OE&H Submission on Proposal- Rocglen Coal Extension Project (10_0015)

The Office of Environment and Heritage (the Office) refers to the Project Application, Environmental Assessment (EA) and accompanying information provided for the proposed Rocglen Coal Extension Project (10_0015) received on 2 March 2011.

ATTACHMENT 1 – KEY ISSUES IDENTIFIED IN DECCW ADEQUACY REVIEW OF ENVIRONMENTAL ASSESSMENT FOR ROCGLN COAL EXTENSION PROJECT (10 0015)

Figure 1: Conceptual Rehabilitation Plan (note that configuration of the final void must be consistent with the Rehabilitation Management Plan)

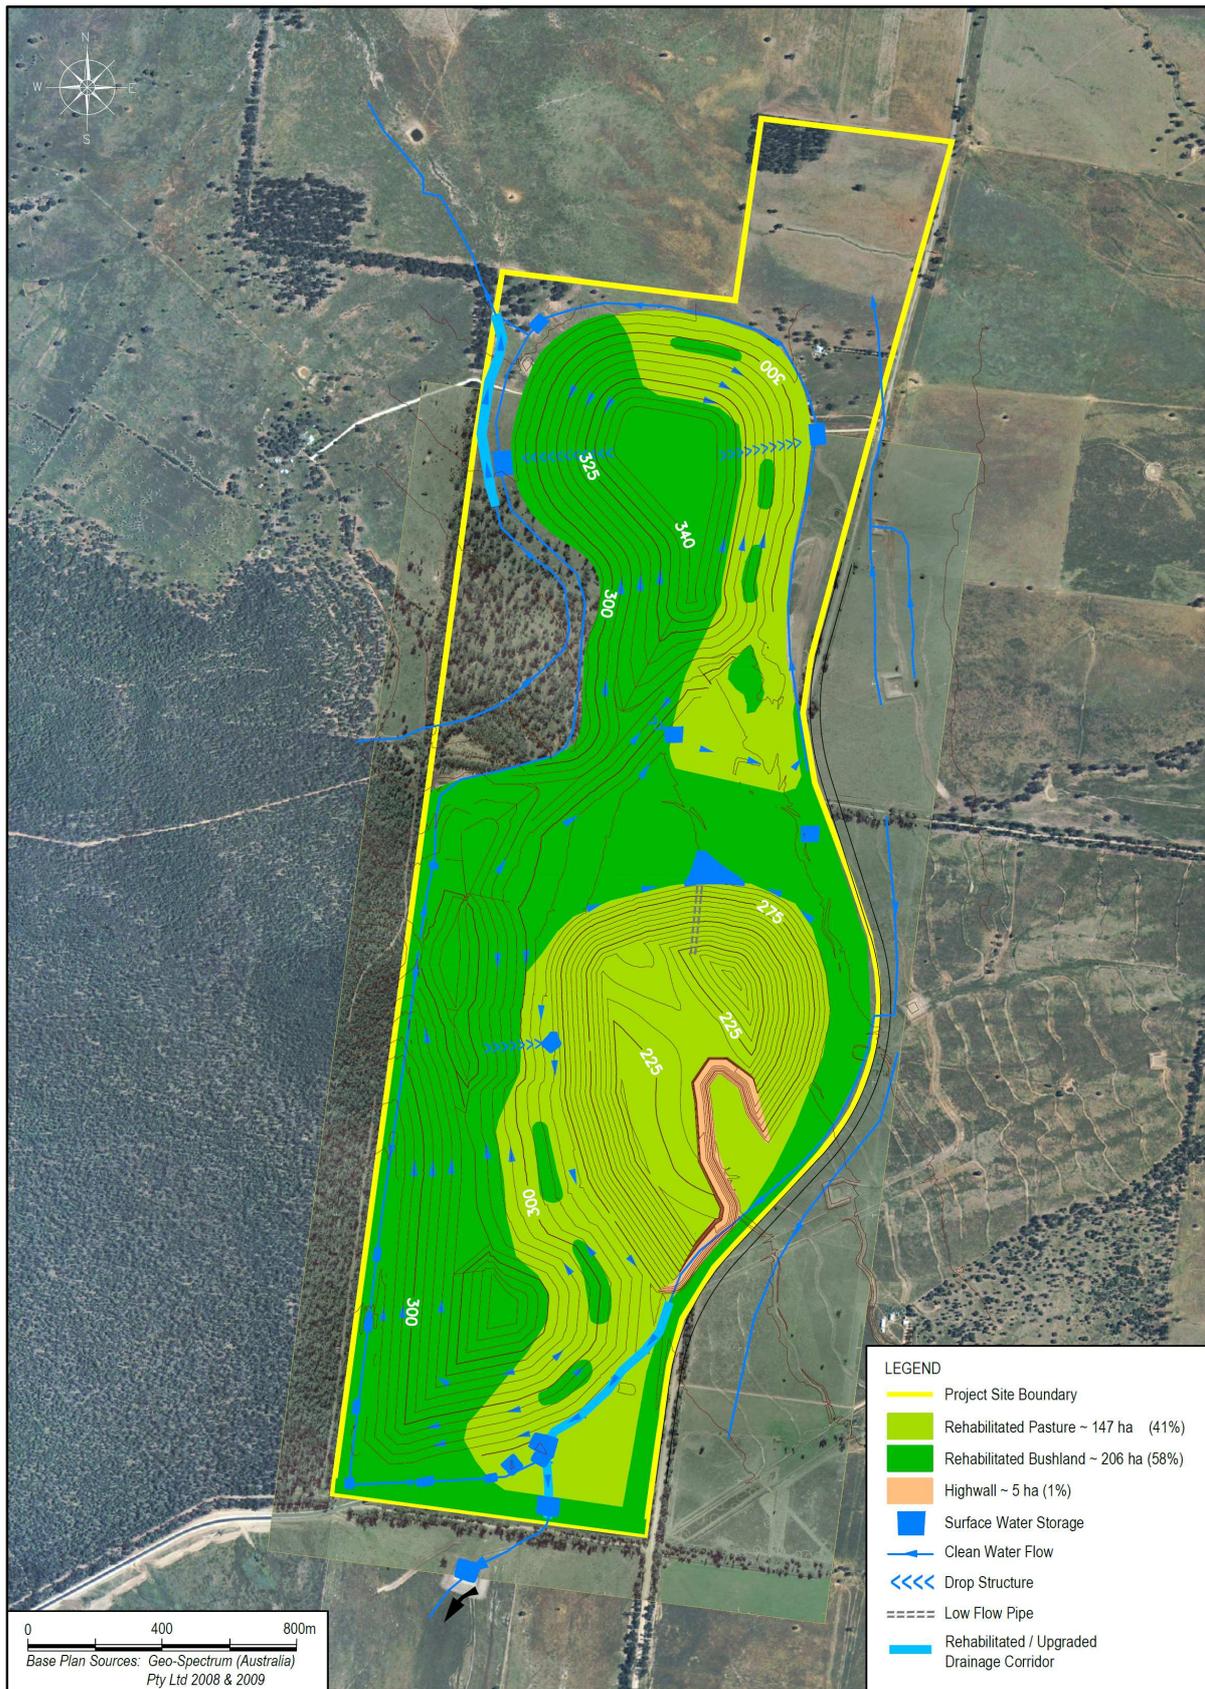
It is proposed that the final void be backfilled to an elevation above 250m AHD, with an exception of about 38ha in the southern end of the pit where the surface levels will be in the range of 225- 250 AHD. This will allow formation of surface water in the southern end of the pit which will increase in salinity over time.

The final void design does not meet mining best practice as it will become a permanent and ongoing liability to the State of NSW. The void will act as a permanent groundwater sink, resulting in groundwater losses to evaporation and water within the void becoming saline over time.

The Office expects that the final void footprint is minimised and that the depth of the void is at least above the final groundwater recovery level such that a permanent groundwater sink is not developed.

The final void and landform should also consider opportunities for integration of boundary development across adjacent mining operations and to potentially utilise final void space across the mines.

Modify final landform, mine planning and final void design to minimise void area and depth. Ideally the mine should be designed to meet world best practice and avoid any final mining void.
